Planning consultation: Application for approval of matters reserved by conditions imposed under P/84/16/PL relating to conditions 3- Foul water drainage scheme, 4- Surface water drainage scheme, 5- Site safety plan, 7- Implementation of a programme of archaeological work, 8- Golf Course management plan, including mitigation & 9- Details of placement of nesting opportunities for birds.

Location: Church Farm Holiday Village Church Lane Pagham PO21 4NR

SUMMARY OF NATURAL ENGLAND'S ADVICE

NO OBJECTION

Figure 2. Objectives 1 and 2 Prescriptions

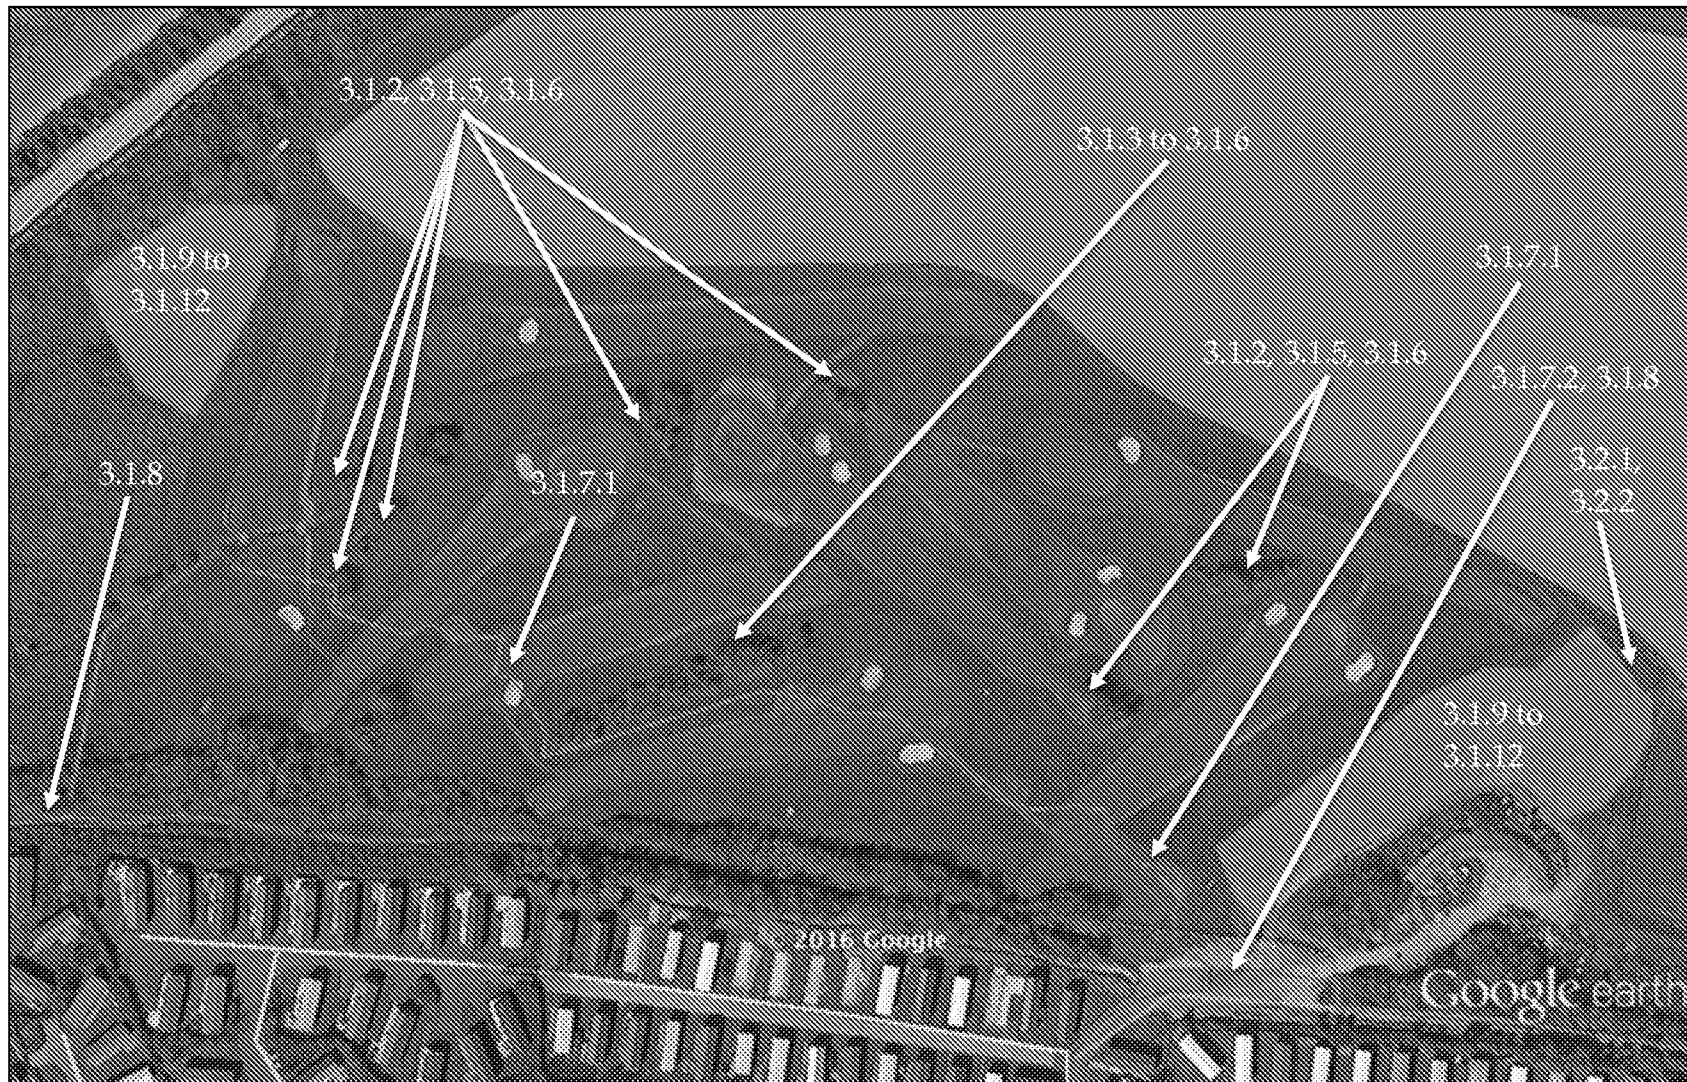
Natural England's view is that the areas of meadow creation to the north and south of the golf course, alongside the tree and scrub thinning and removal within the golf course and restriction of public access in the winter, is sufficient to maintain foraging habitat for brent geese. The Golf Course Management Plan prescriptions in table 1 and illustrated on figure 2 are sufficient to achieve

the necessary habitat creation.
